From: Welham Architects  
Sent: 18 Apr 2024 16:01:14 +0100  
To: PlanningAndGrowth Email  
Subject: [EXTERNAL]:24/00664/FUL- Request for further information  
Attachments: SMI-100-02- Proposed Plans- Elevations and Sections.pdf

**RE: 38 Ashley Road Keyworth Nottinghamshire NG12 5FJ**

Proposed Side Elevation- South

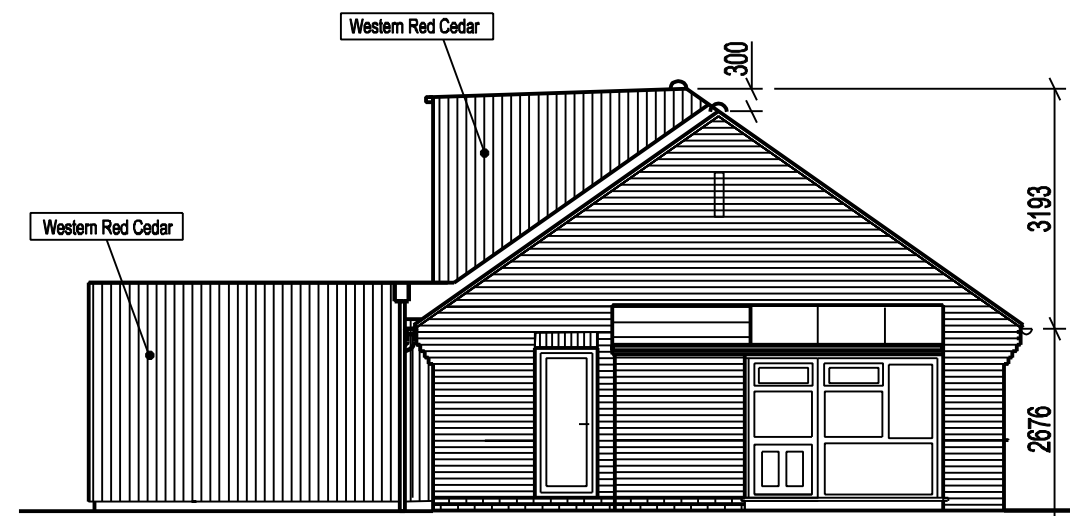
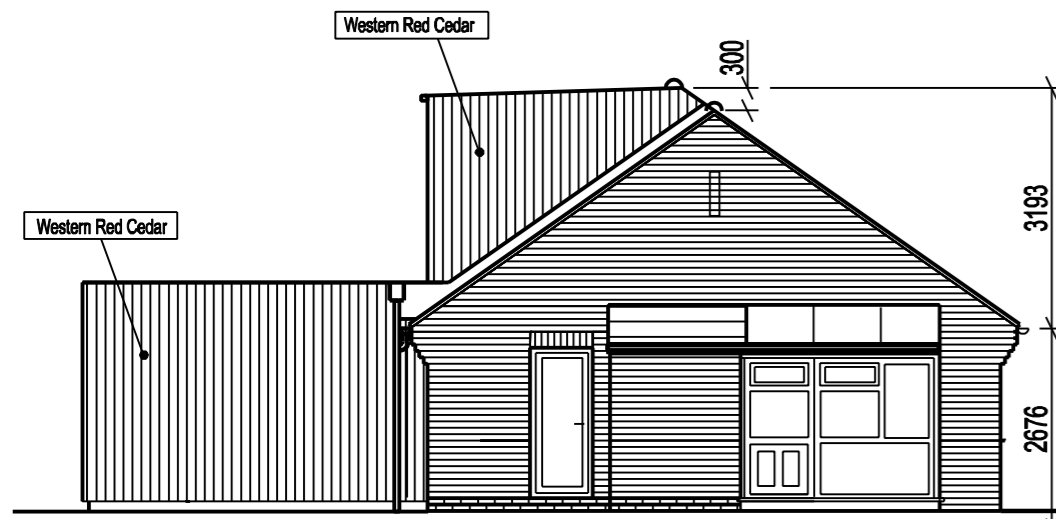
Please find an updated drawing of SMI/100/02/- including **a dimension for the proposed loft extension** and **renaming the side elevation**.

Proposed Section

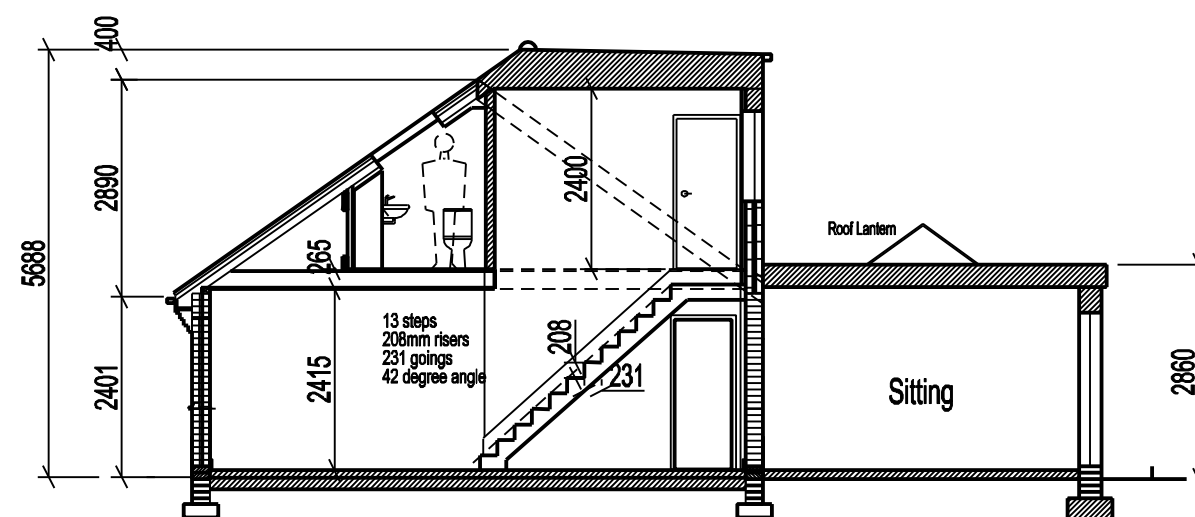
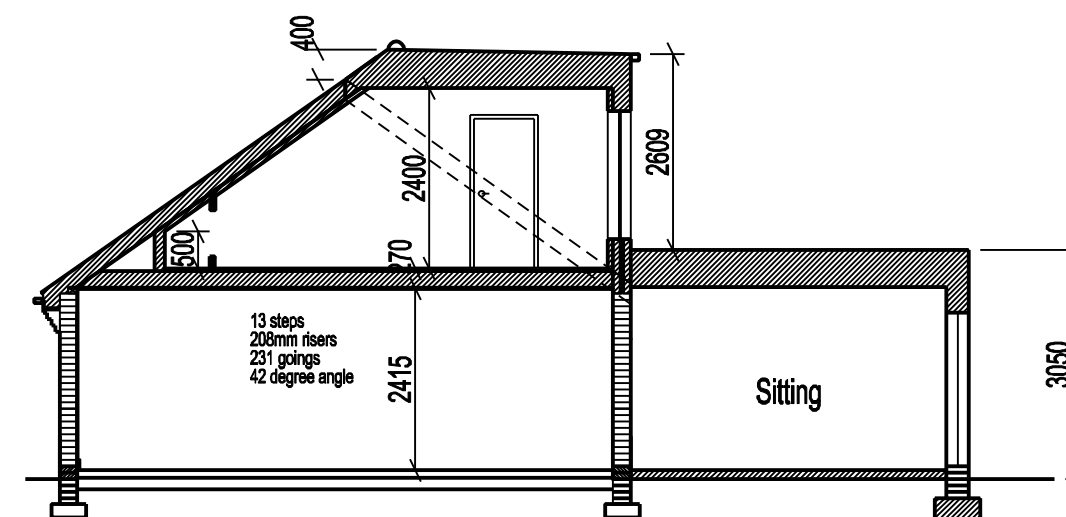
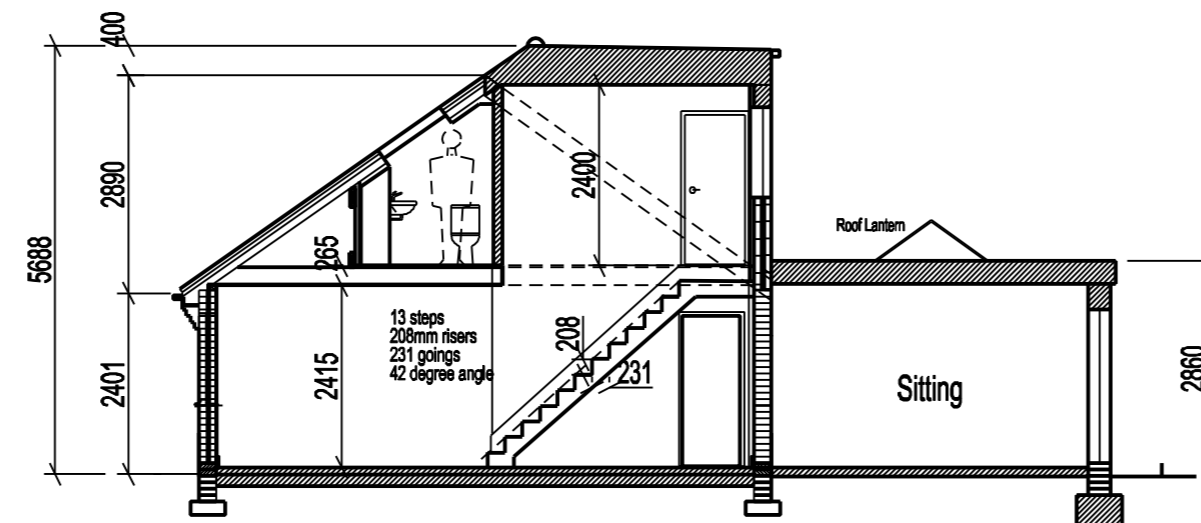
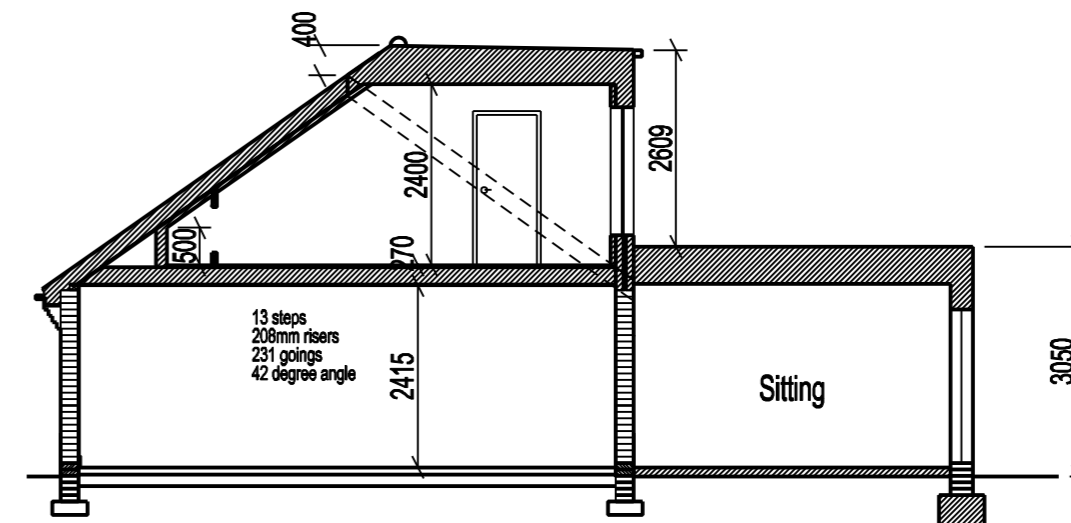
1. **Confirm how the roof will be supported-** Firstly please note that we are in the process of engaging Andy Mann Structural Designers to design the structural elements and provide calculations of any beams that are required.

2. **Confirm if any structural changes will be made to the existing roof-** We can confirm that structural changes will be made to the rear roof and not the front roof.

Secondly, we can provide you with a copy of the report when it is completed. In brief the initial discussion is to raise the gable walls in Brick and Blockwork to the height of the new ridge. The existing ridge will remain in place and a new ridge will be installed.

The new ridge will be supported on external and internal walls. The rear roof will be removed and replaced with a timber studwork 50 x 150mm timbers (tbc) wall and roof. The front wall of the extension will be based on the existing rear wall.

It is anticipated that the floor will require some strengthening of further timbers joists between the existing floor joists.
